Subject: Comment Response Letter
155 Sheridan Street – Portland, Maine

On behalf of BD Sheridan, LLC we are pleased to respond to the civil-related comments provided by multiple reviewers.

Woodard & Curran, Stormwater and Civil Engineering

DRAWING NO. C-44

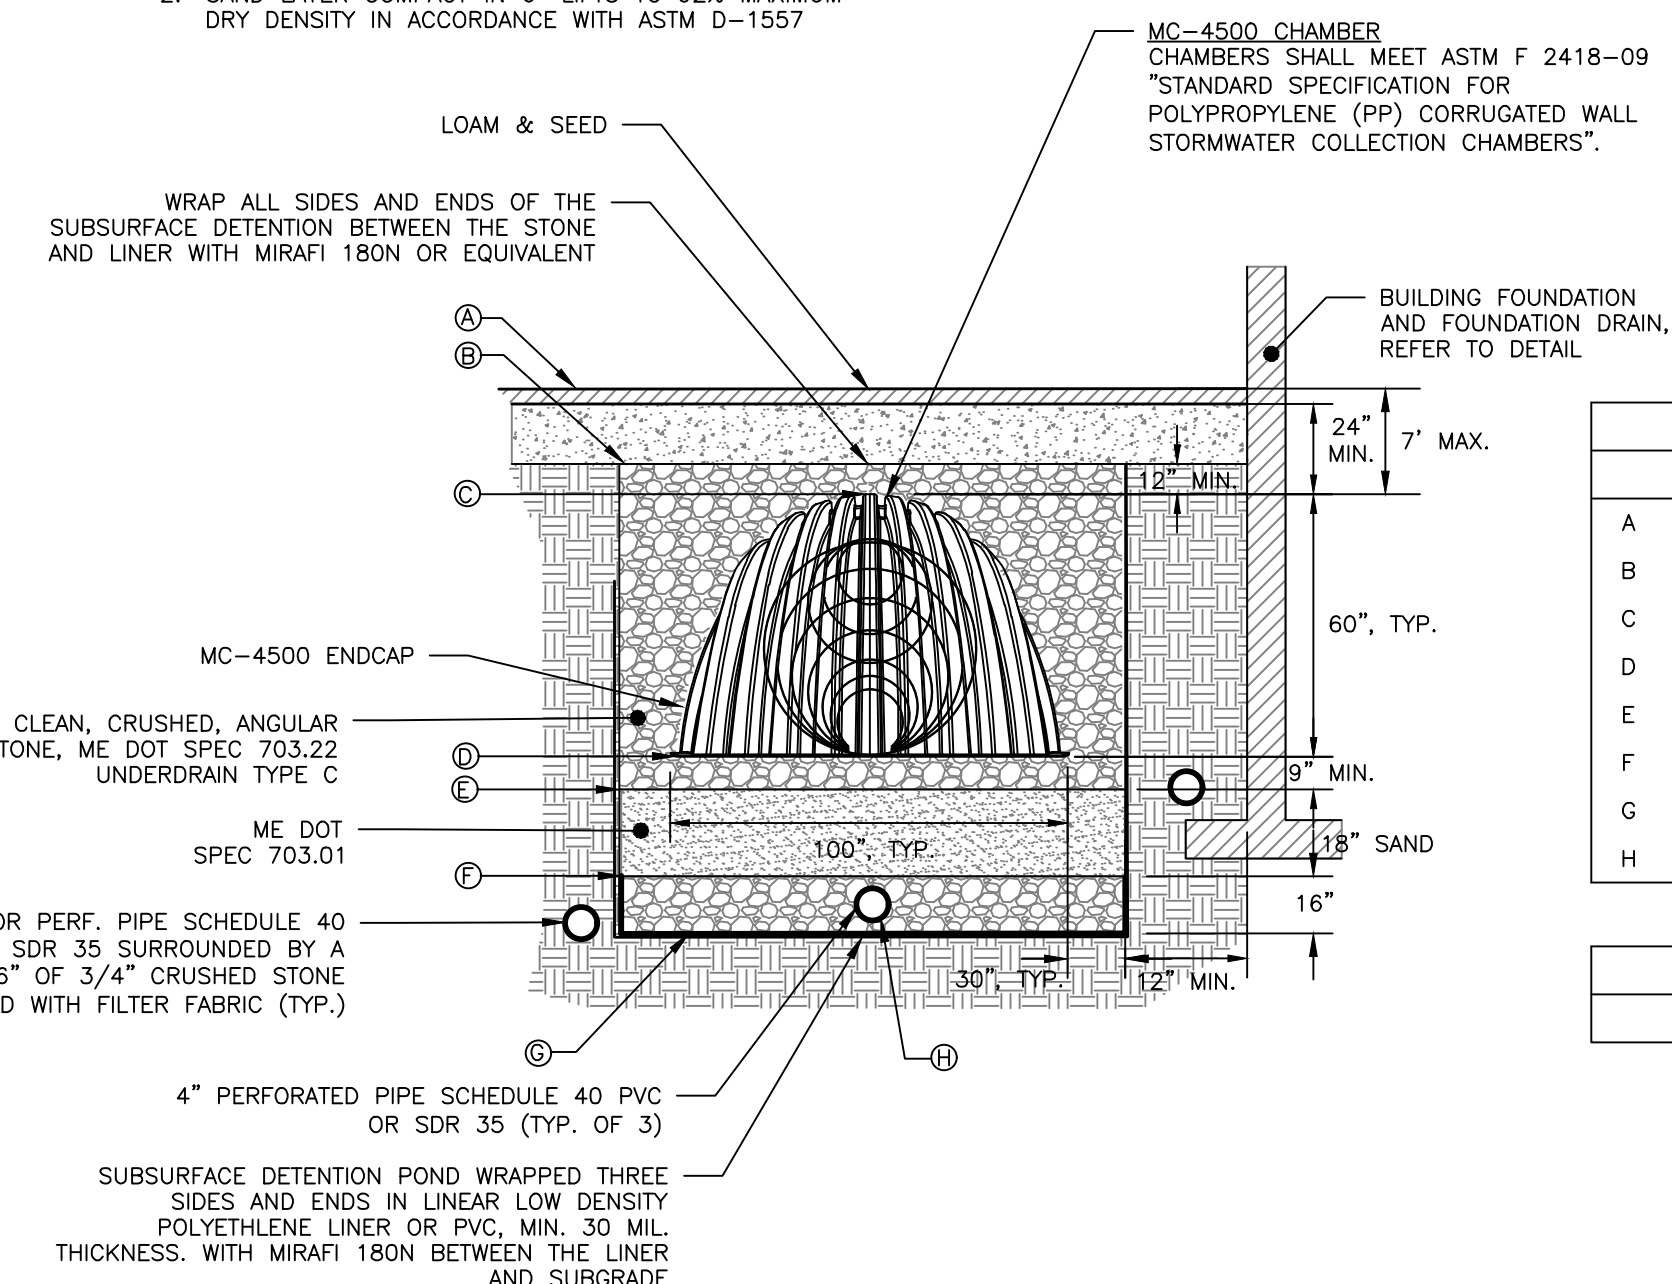
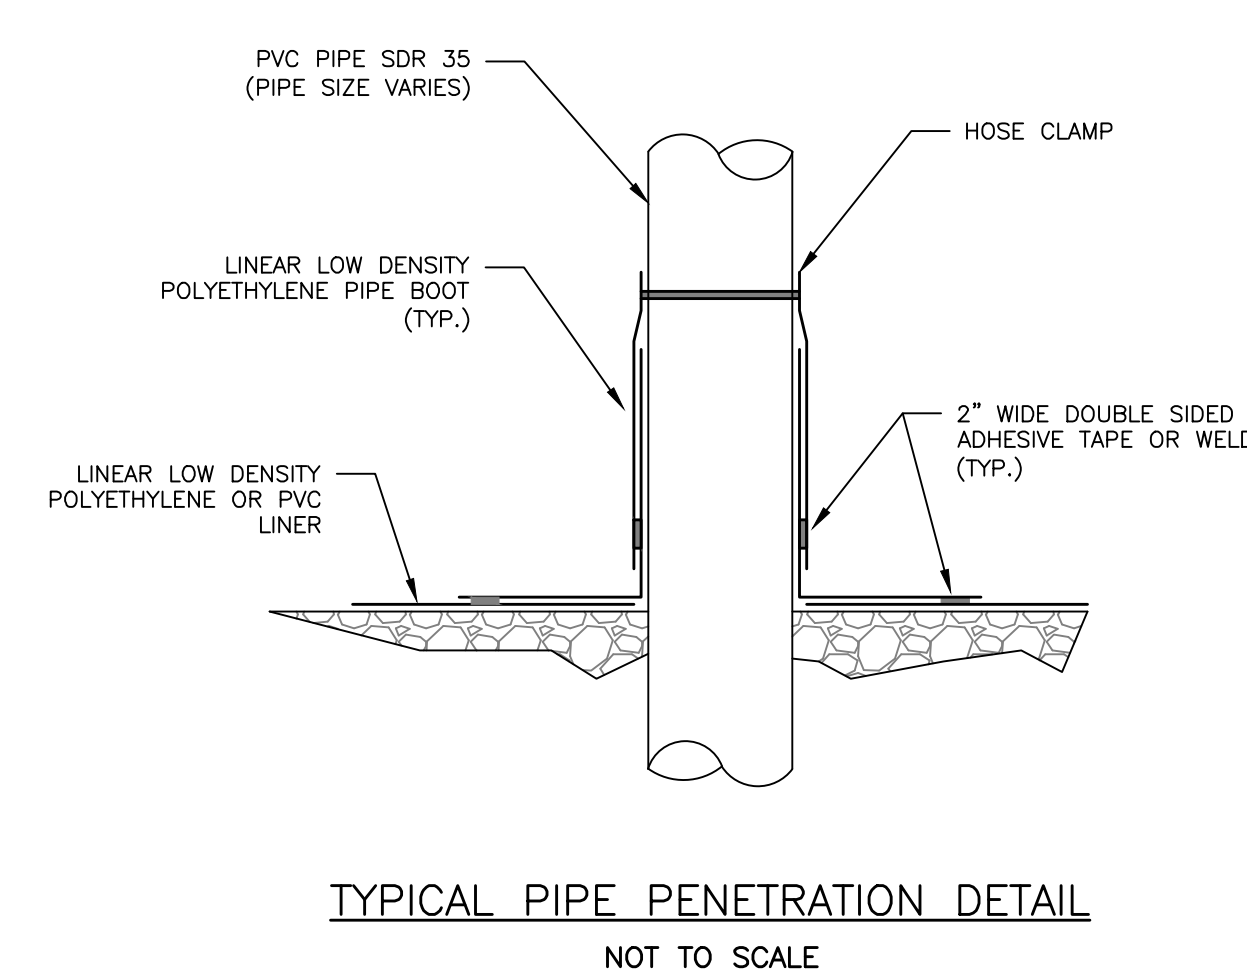
Comment – ***General Standard:*** *The project will result in an increase in impervious area of approximately 9,783 square feet. As such, the project is required to include stormwater management features for stormwater quality control. We have the following comments on the proposed treatment system.*

The Applicant has indicated in the Stormwater Management Report that the subsurface sand filter was sized only to treat runoff generated from the roof of the proposed building and that landscaped areas will not be directed into the system. Table 2: Developed Area Treatment and Table 4: Water Quality Volume Table, both depict landscaped areas being treated by the subsurface sand filter. Please clarify if the proposed subsurface sand filter will treat the proposed landscaped areas.

Additionally, if landscaped area is to be directed towards the subsurface sand filter, the filter surface area provided in Table 3 should be revised accordingly.

- i. *Table 4 in the Stormwater Management Report specifies a provided storage volume for the subsurface sand filter of 1,086 cubic feet, however, the modeled storage for pond 1P is approximately 2,222 cubic feet. Please clarify the intended subsurface filter size.*
- ii. *The Time of Concentration flow path for Pre-Development does not appear to represent the most hydrologically remote point.*
- iii. *It appears that a portion of subcatchment 3 shown on the Post-Development watershed, is directed towards the subsurface sand filters and a portion flows directly onto Sheridan Street. Please clarify how flow from the rear of the lot is directed way from the proposed subsurface sand filters.*

Response – The report has been revised to state that the landscaped area within the rear private patio spaces is to be redirected and treated by the USSF system as well.

The total developed area and developed area with treatment as recorded in Table 2 include the area of the building that will be disturbed during the construction process. As such, the tributary area as recorded in Table 4 is less than the developed areas and represents the rear patio space entering the USSF system to be treated and included in the water quality volume calculations. Therefore, the USSF filter area is sized to treat at least 95% of all new impervious area and 80% of all disturbed area. The report has been revised to more clearly differentiate the two areas. The USSF filter area has also been updated and sized to the tributary areas.

- i. Table 4 has been updated to reflect the storage as recorded in the HydroCAD report. Note that the water quality storage is provided in the MC-4500 chambers and end caps, and the surrounding stone only and the number recorded in Table 4 reflects storage from those components only.
- ii. The Pre-Development Watershed Map has been revised to reflect a longer flow path as starting from a more hydrologically remote point. The HydroCAD model was updated as well.
- iii. The runoff from the rear part of subcatchment 3 is proposed to enter the underdrain installed alongside the retaining wall and connect to the outfall stormdrain of the USSF, thus bypassing the system before entering Sheridan Street.

BRICK DRIVEWAY APRON LAYOUT DETAIL
NOT TO SCALE

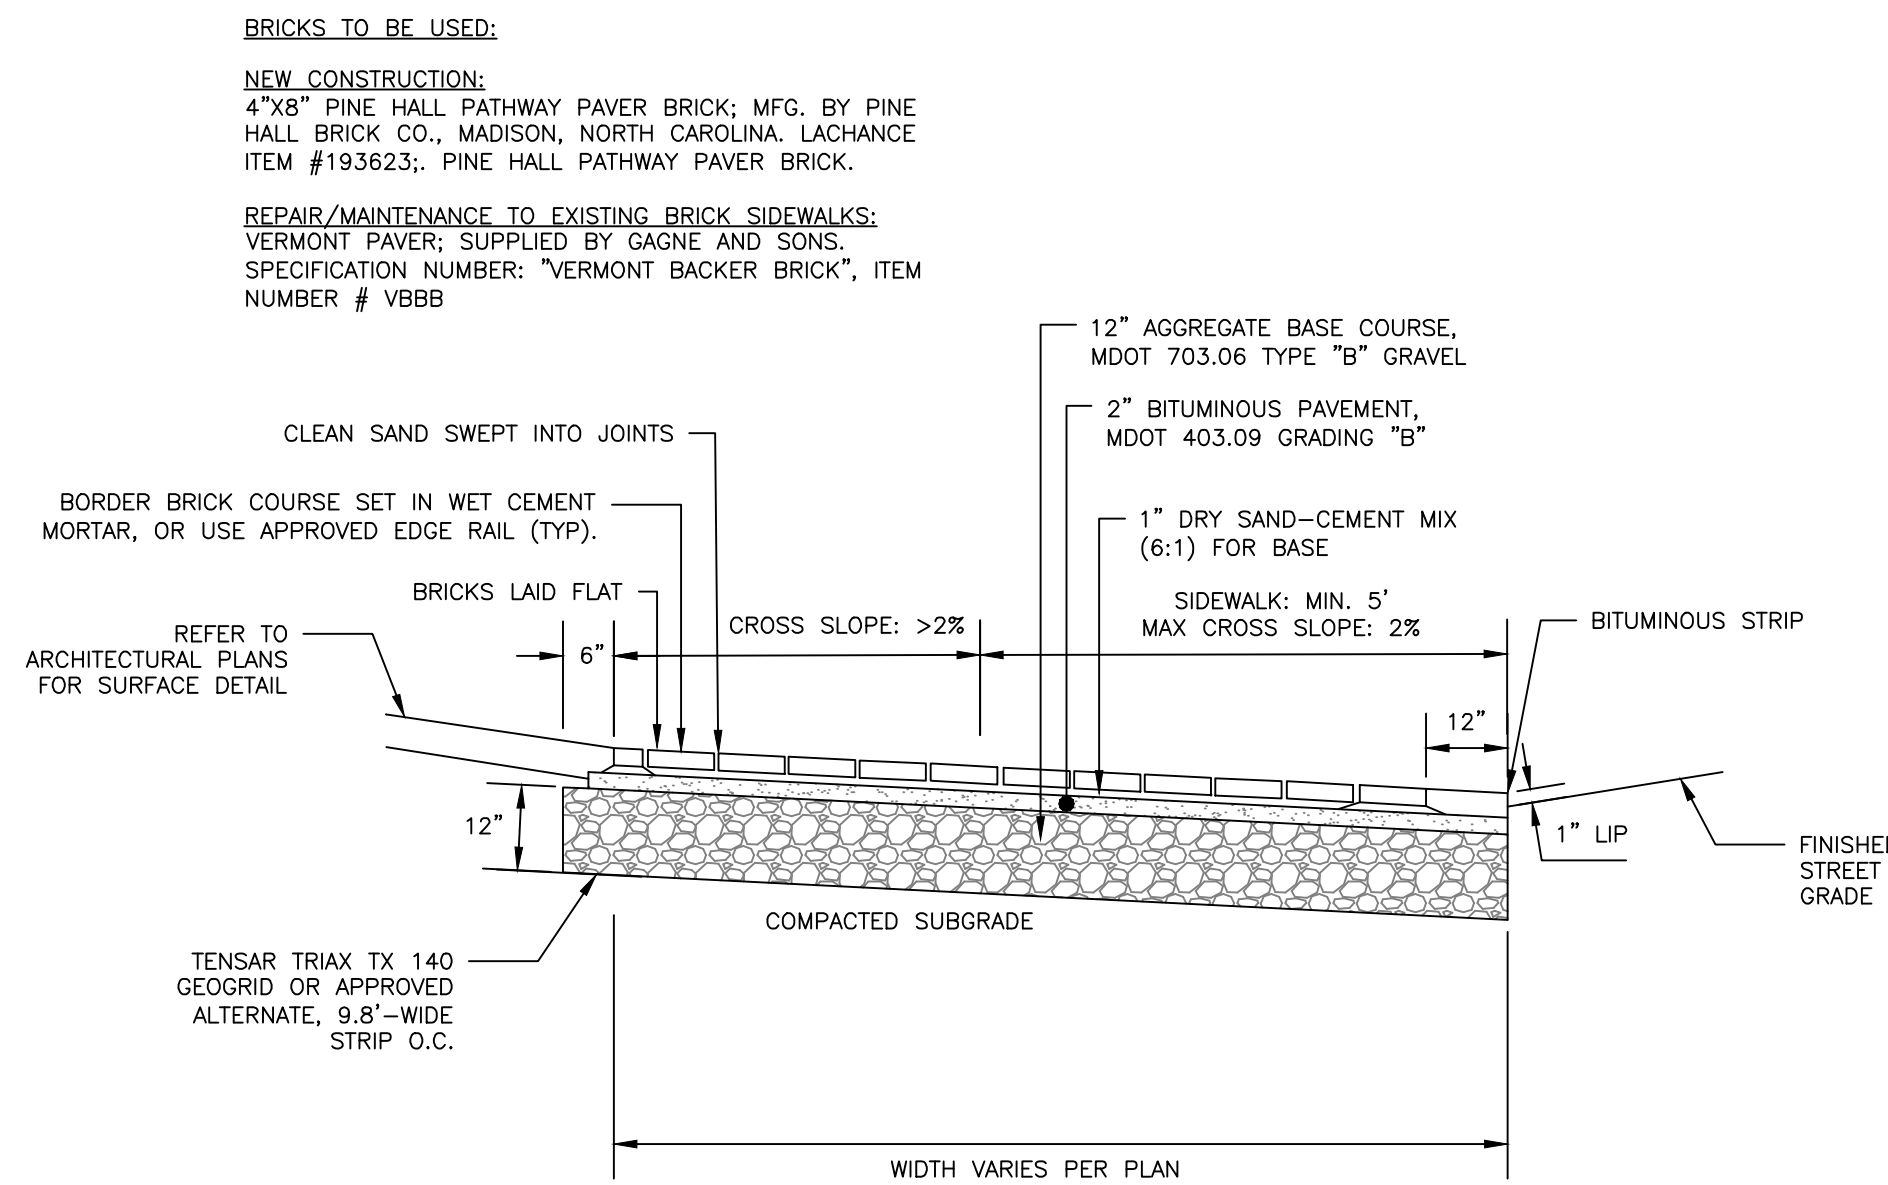
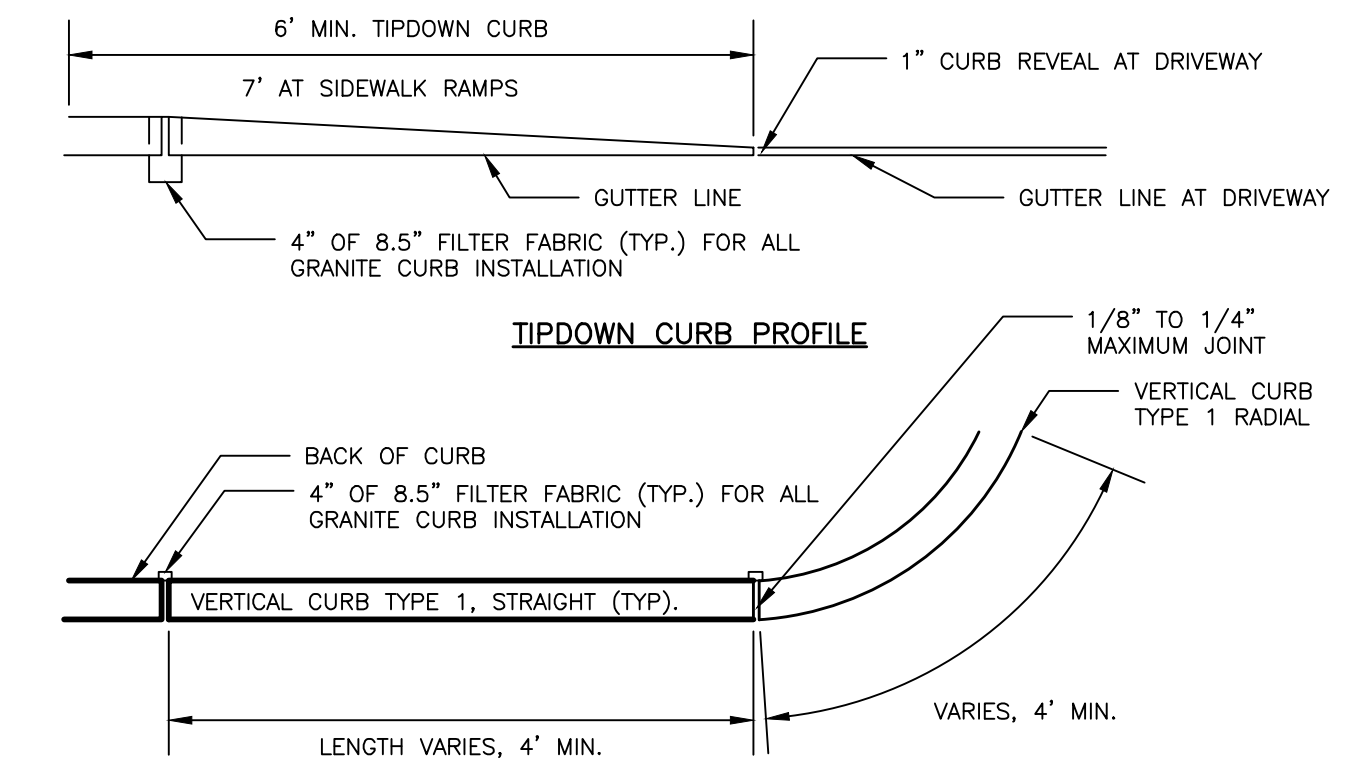
Comment – *The proposed driveway opening at the garage is 18-feet wide. Technically this width does not require a waiver from City standards given that the width increases at the property line (the minimum width permitted by the City is 20 feet). I find the driveway configuration to be acceptable. I would note that the driveway apron shall provide for a maximum 2% cross slope along the sidewalk or pedestrian route.*

Response – Thank you for your review; the brick driveway apron detail has been updated to reflect the maximum 2% cross slope along the pedestrian walkway route (minimum five feet).

CITY OF PORTLAND: LOCAL ROAD BITUMINOUS PAVEMENT PROFILE
NOT TO SCALE

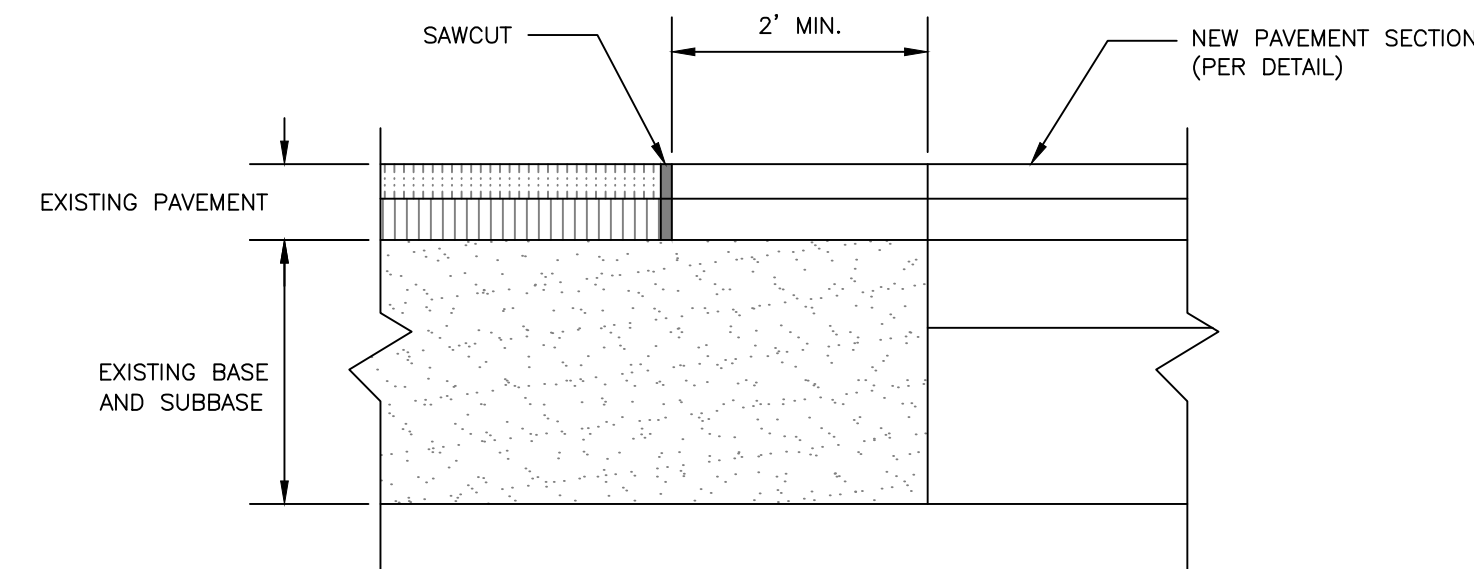
Comment – *The provided bituminous pavement detail references both 9.5 and 12.5 mm HMA as the surface course. City of Portland Technical Standards require the use of 12.5 mm HMA.*

Response – The detail has been revised to reference 12.5 mm HMA pavement only.
